AMENDED PLAN
Ref. <u>A1</u>

**Proposal for new restaurant for Jack's Fish Bar (Use Class A3)
on land adjacent to Fulney Hall and Springfield's, Camelgate, Spalding, PE12 6ES**

Amendment: Amendments to design and parking area (dwg. nos.
1886-03C, 1886-05B and 1886-06B)

6 Rear Section
1 : 50

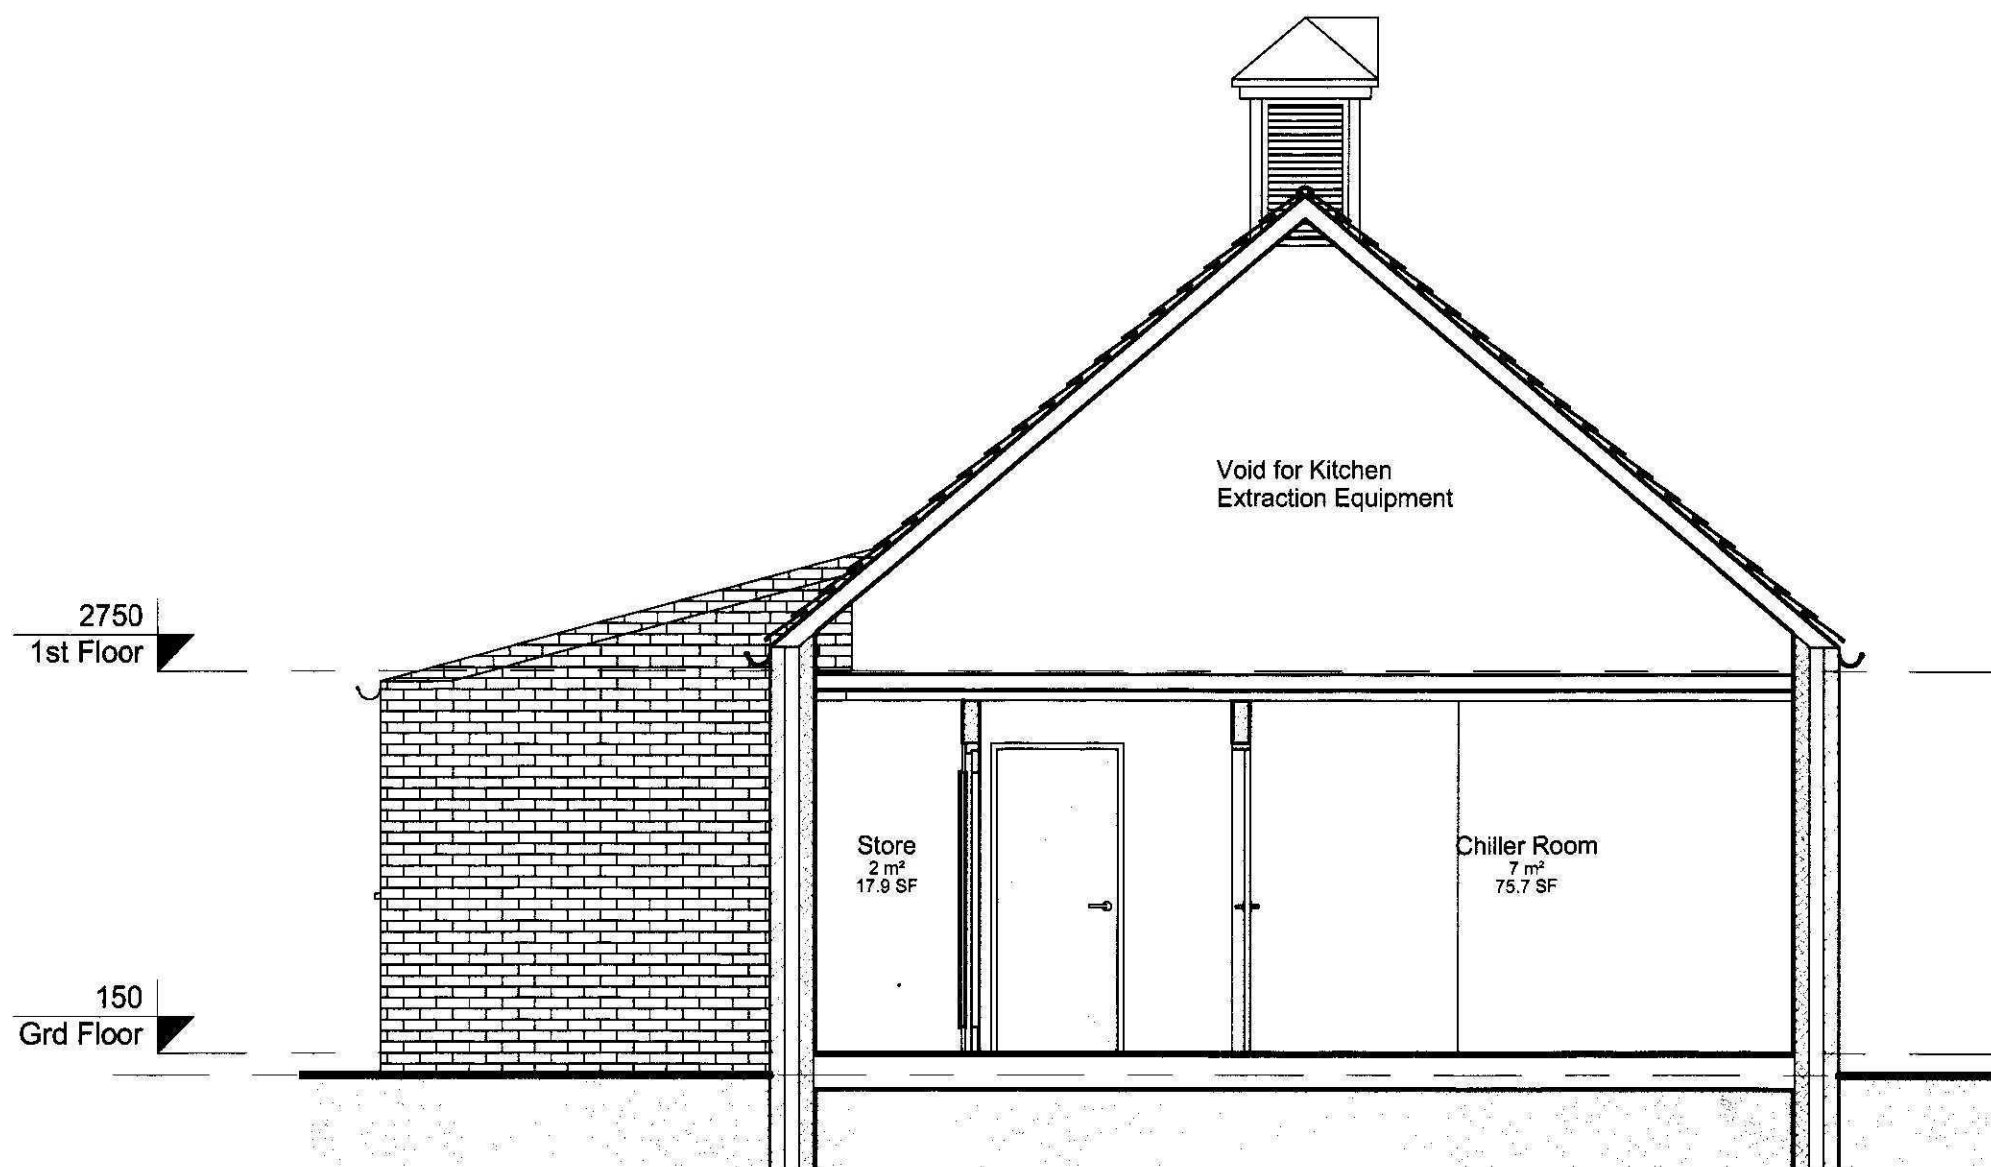
Revised plans show the location of the ventilation and extraction flue. The point of extraction will be in a louvered feature positioned on the rear roof ridge. The precise design and specification for odour management, flue dimensions, its filters and air changes will be dependent on the kitchen design, and this is not yet confirmed. It is a normal expectation for such specification details to be covered by planning conditions.
